Case Officer: Imogen Hopkin

Recommendation: Approve

Proposal: Erection of conservatory to rear of property

PROPOSED G/F

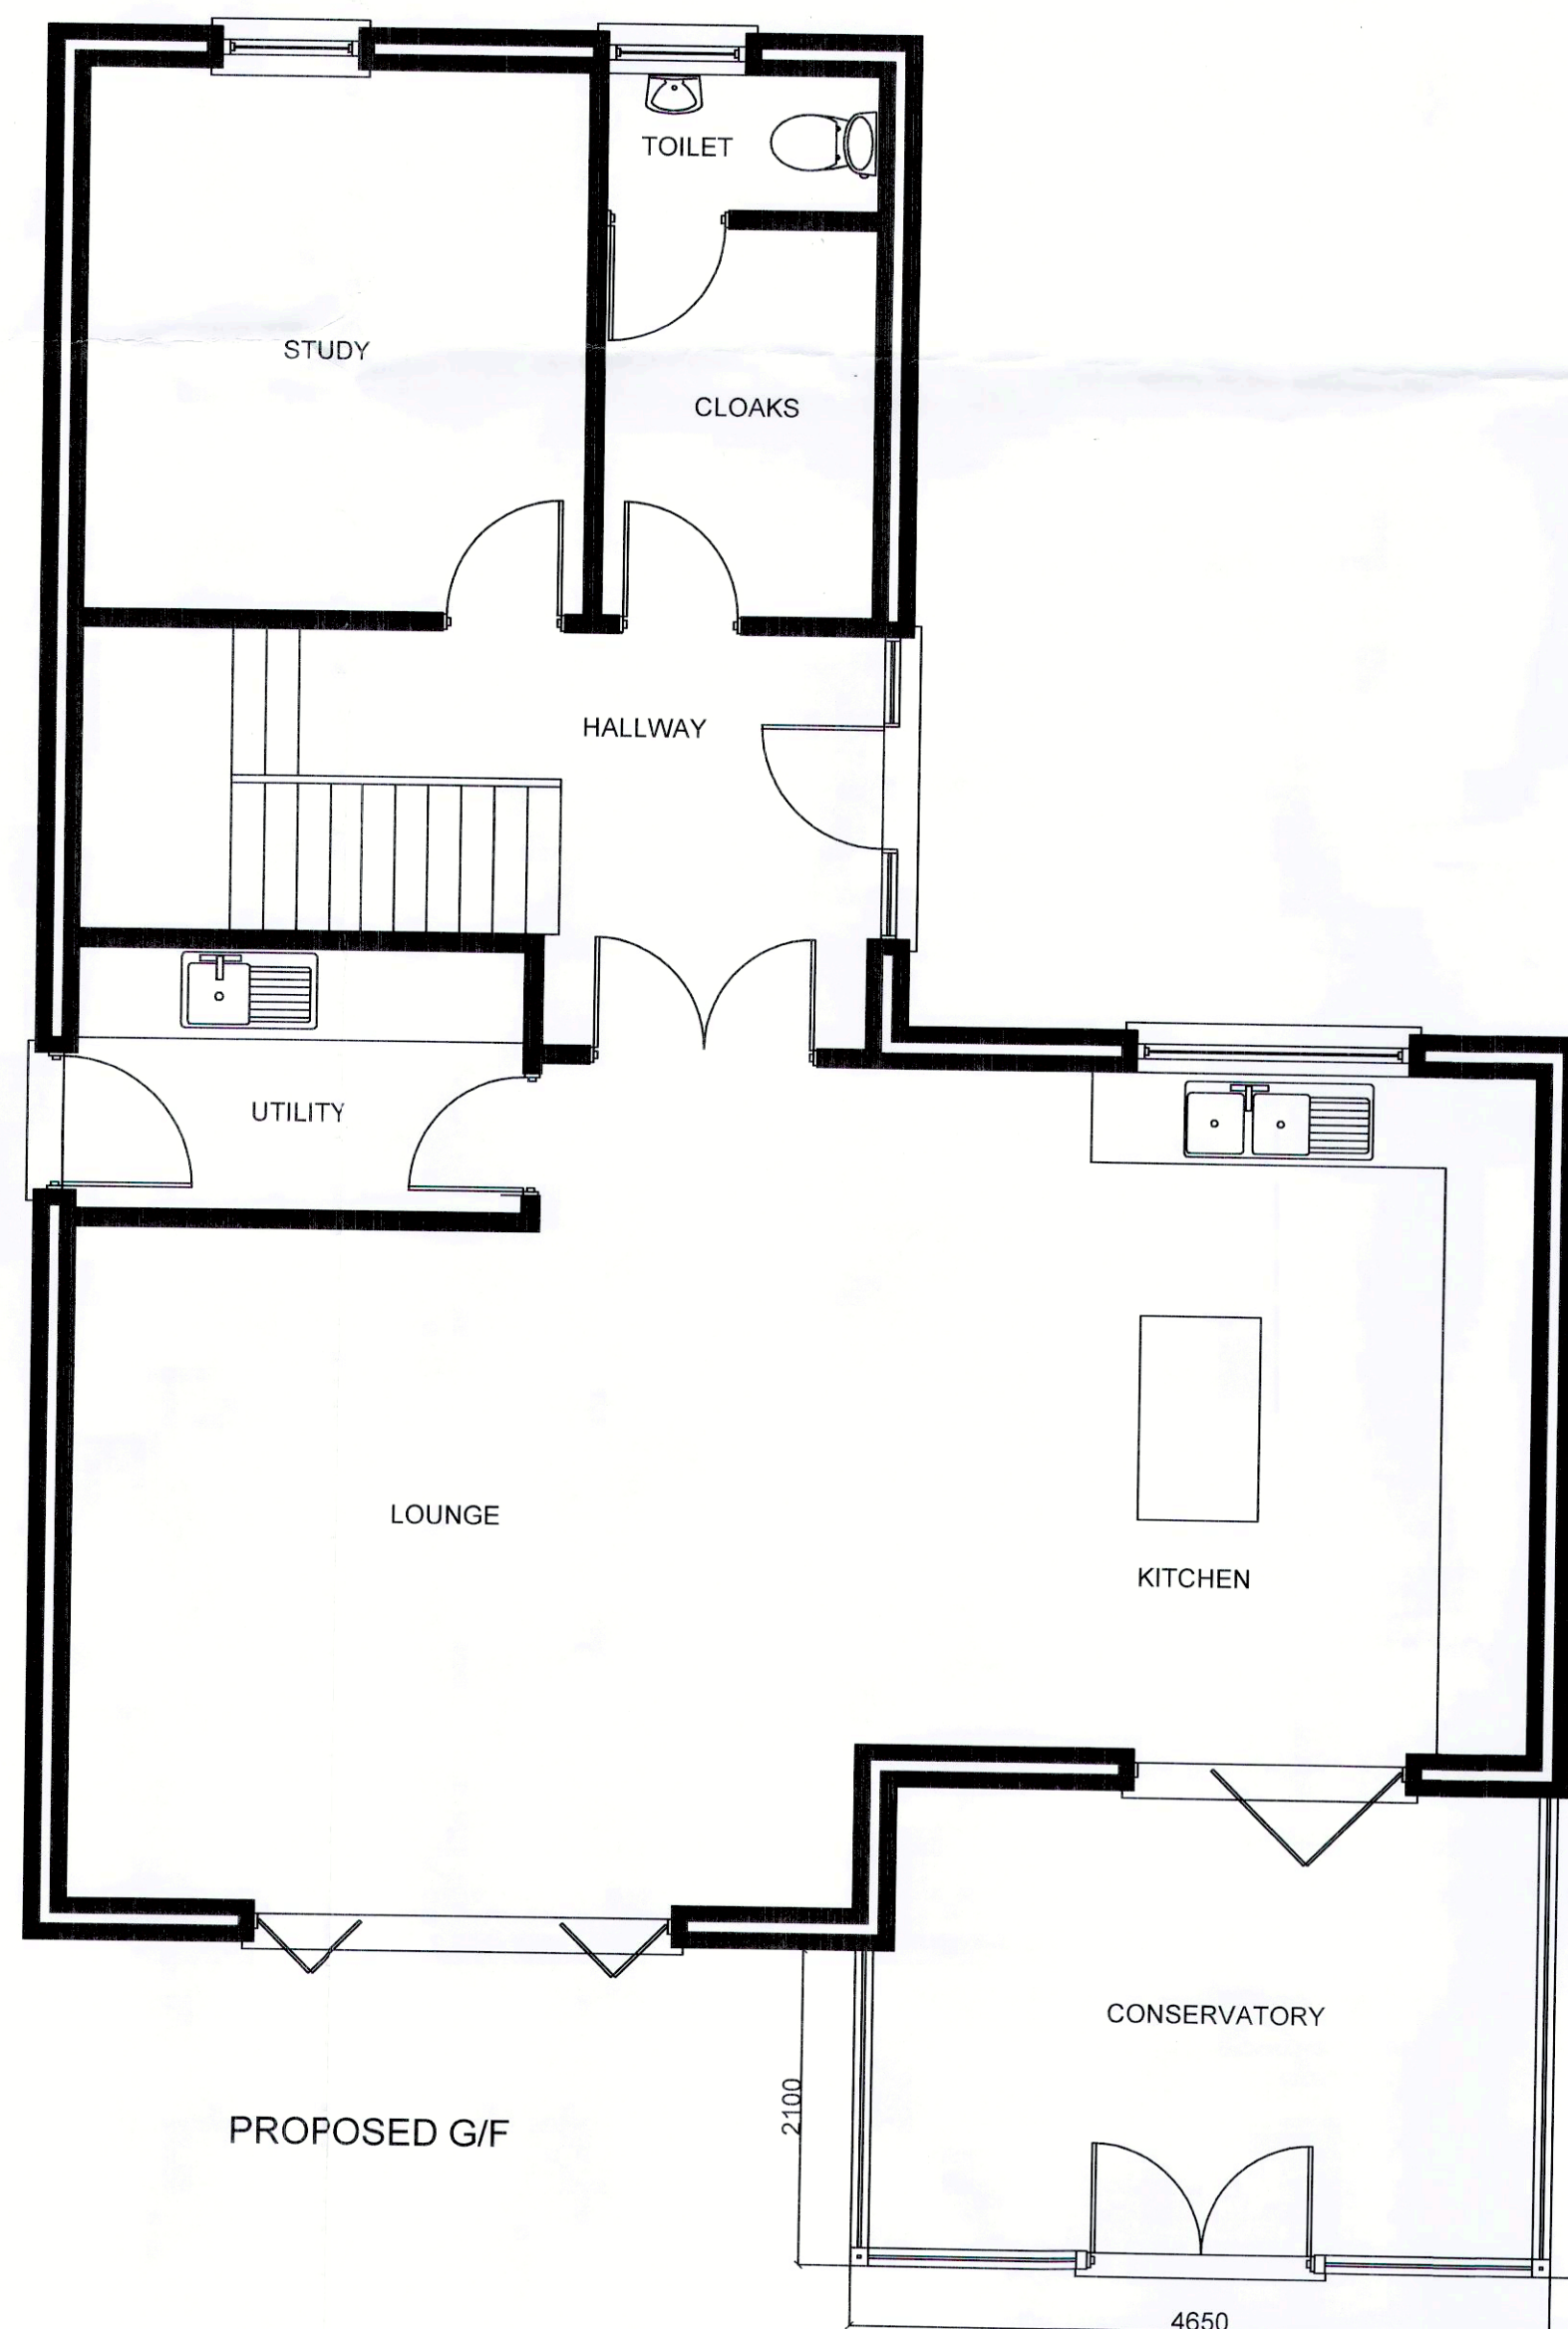
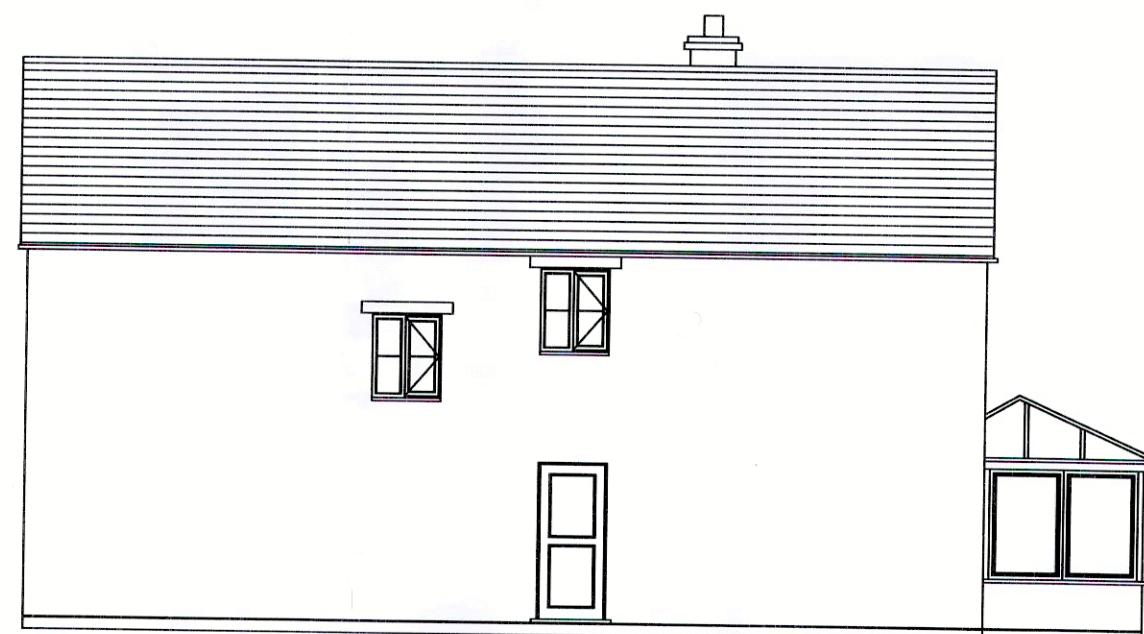
The design of the proposed conservatory results in a slightly awkward arrangement, owing to the stagger in the rear wall of the property. However, it is noted that the extension would be sited entirely to the rear of the property, is modest in size and is screened from the public realm. The proposal would comprise of coursed stonework to match the dwelling and agate grey windows and doors.

The position of the conservatory is central within the site. The conservatory would be approximately 9m from the rear boundary and 9.8m from the eastern boundary, adjacent to No. 13. The position and low height of the conservatory would not result in any overshadowing, loss of light, outlook or loss of privacy as a result of the development.
